**RE: Starview Short Plat (SP-08-00039)**

The Kittitas County Community Development Services Department hereby grants *conditional preliminary approval* to the Starview Short Plat (SP-08-00039) subject to the following conditions:

SP-08-XX

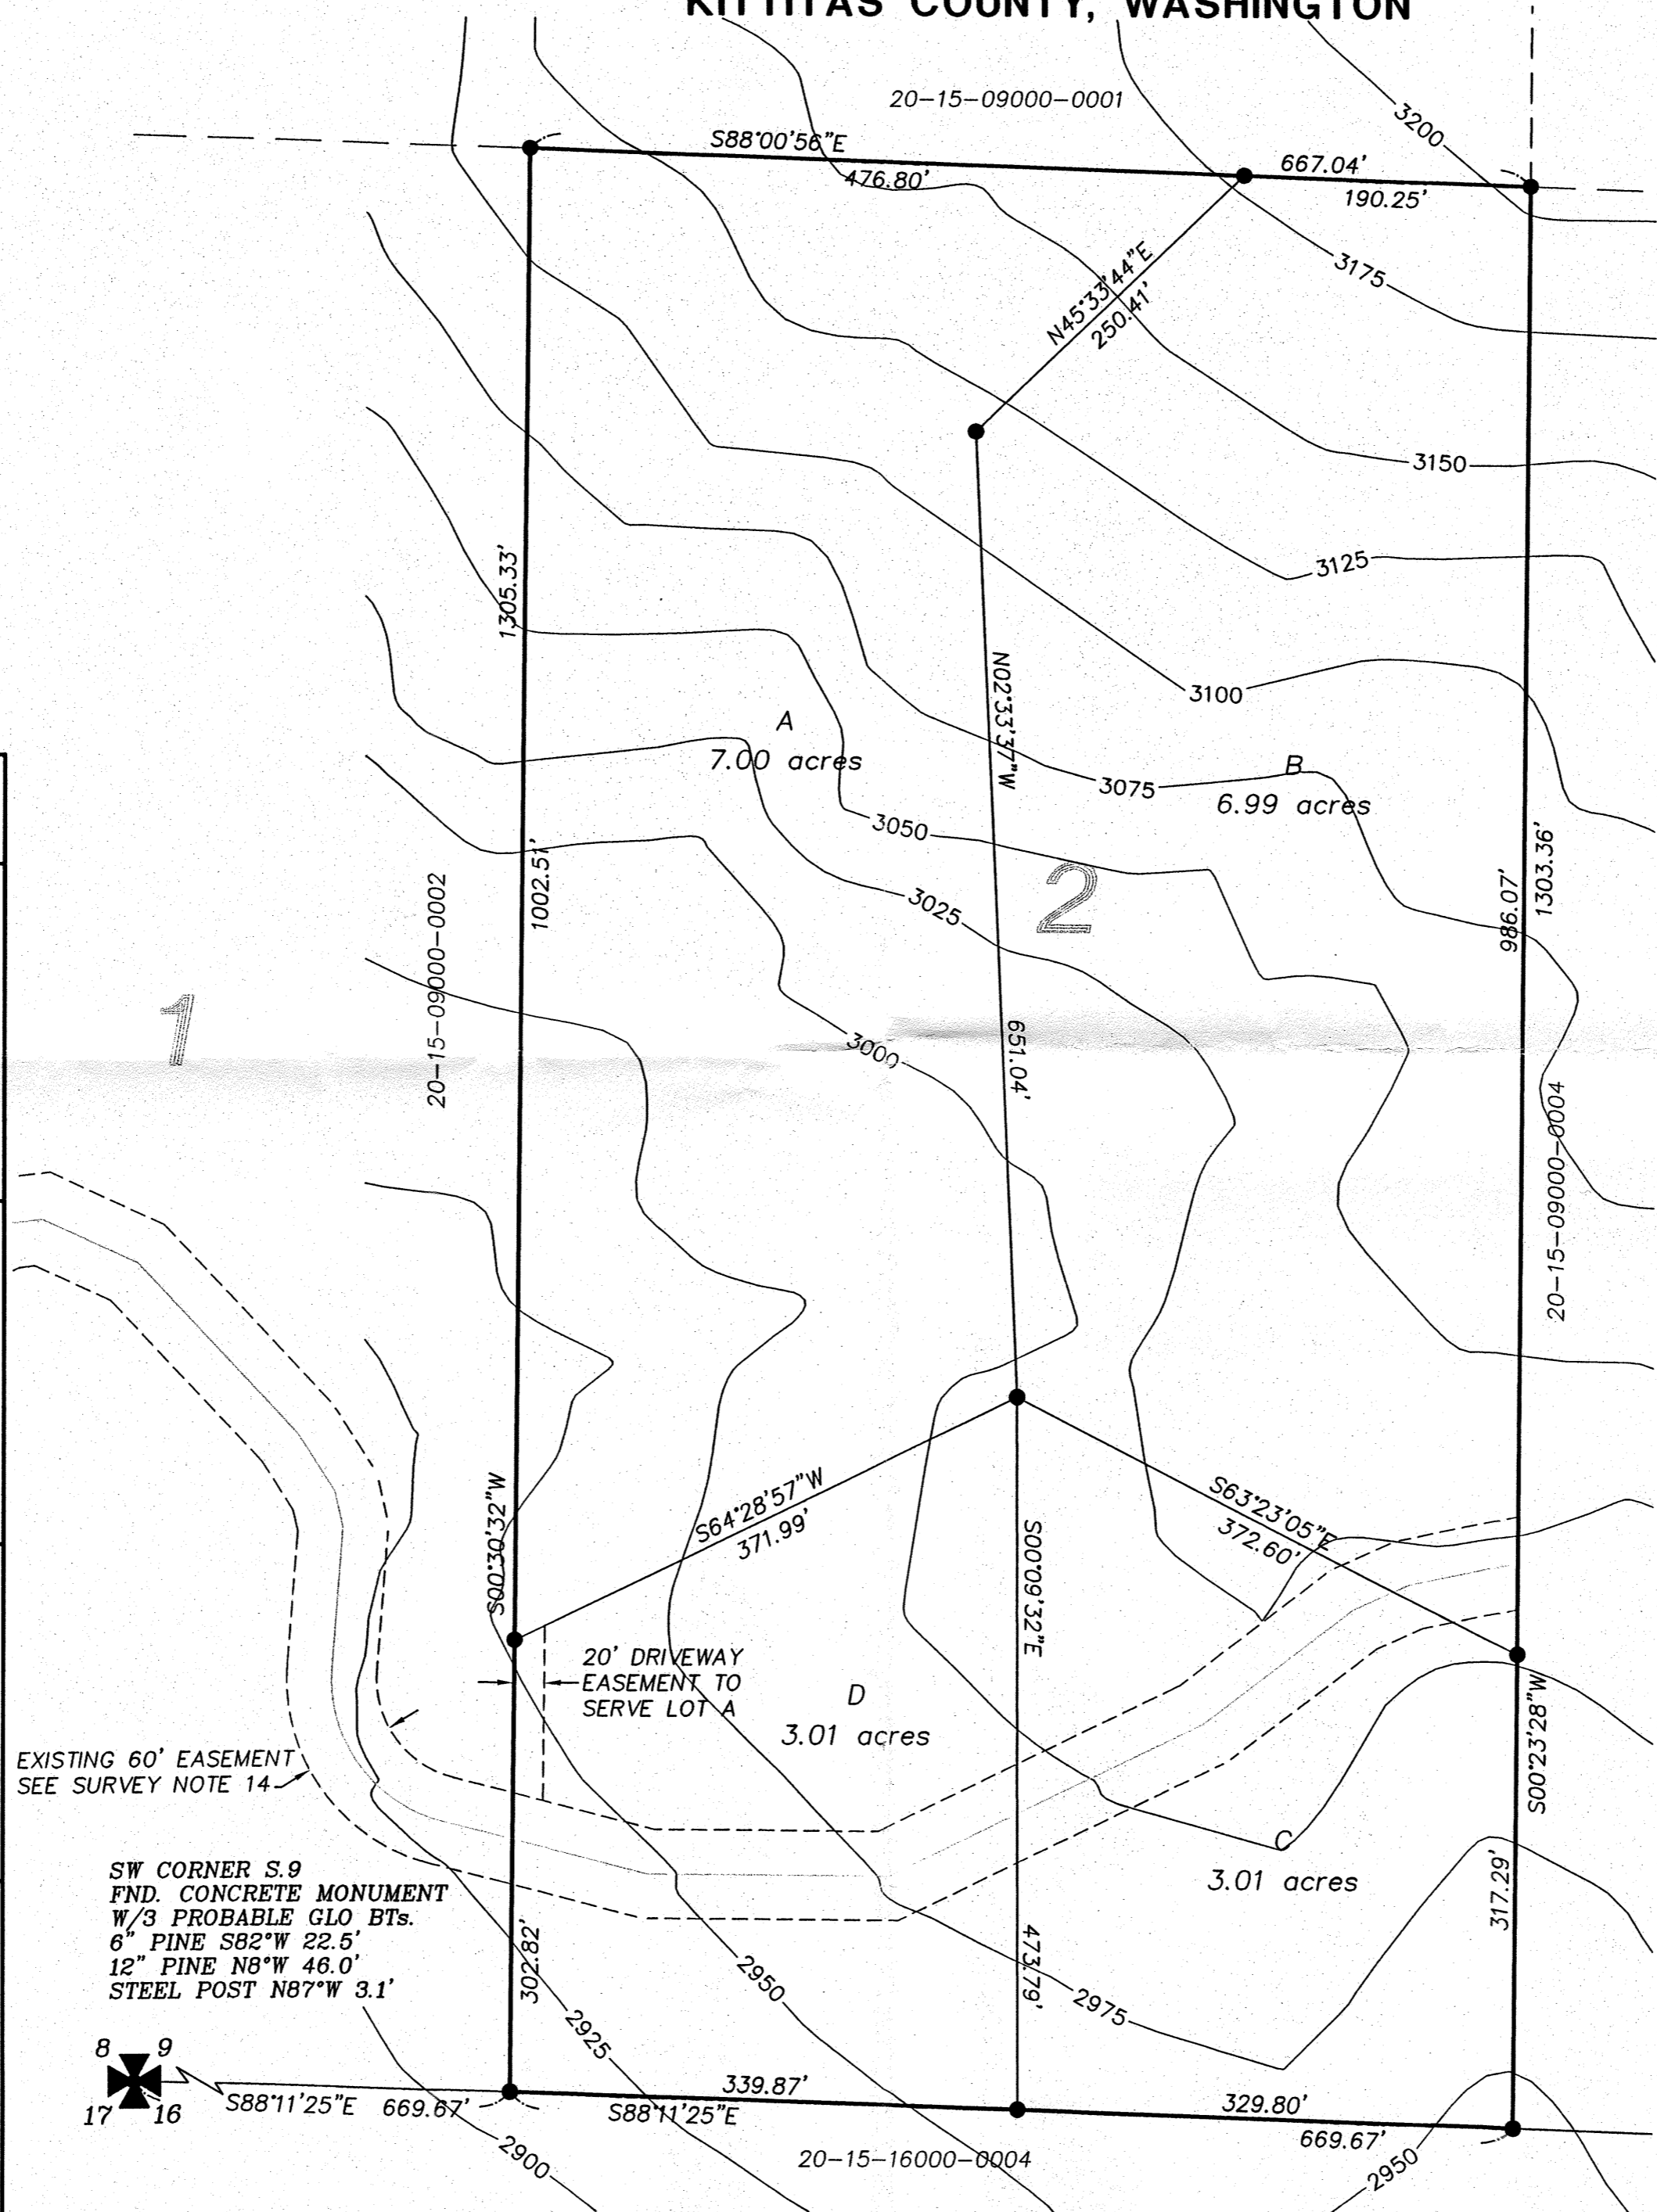
1. The following plat notes shall be recorded on the final mylar drawings:
  - All development must comply with International Fire Code.
  - The subject property is within or near designated natural resource land of long-term commercial significance on which a variety of commercial activities may occur that are not compatible with residential development for certain periods of limited duration. Commercial natural resource activities performed in accordance with county, state and federal laws are not subject to legal action as public nuisances. (RCW 7.48.305)

- The approval of this division of land includes no guarantee that there is a legal right to withdraw groundwater within the land division. The approval of this division of land provides no guarantee that use of water under the ground water exemption (RCW 90.44.050) for this plat or any portion thereof will not be subject to curtailment by the Department of Ecology or a court of law.

2. Both sheets of the final mylars shall reflect short plat number SP-08-00039 and an accurate legal description shall be shown on the face of the final plat.
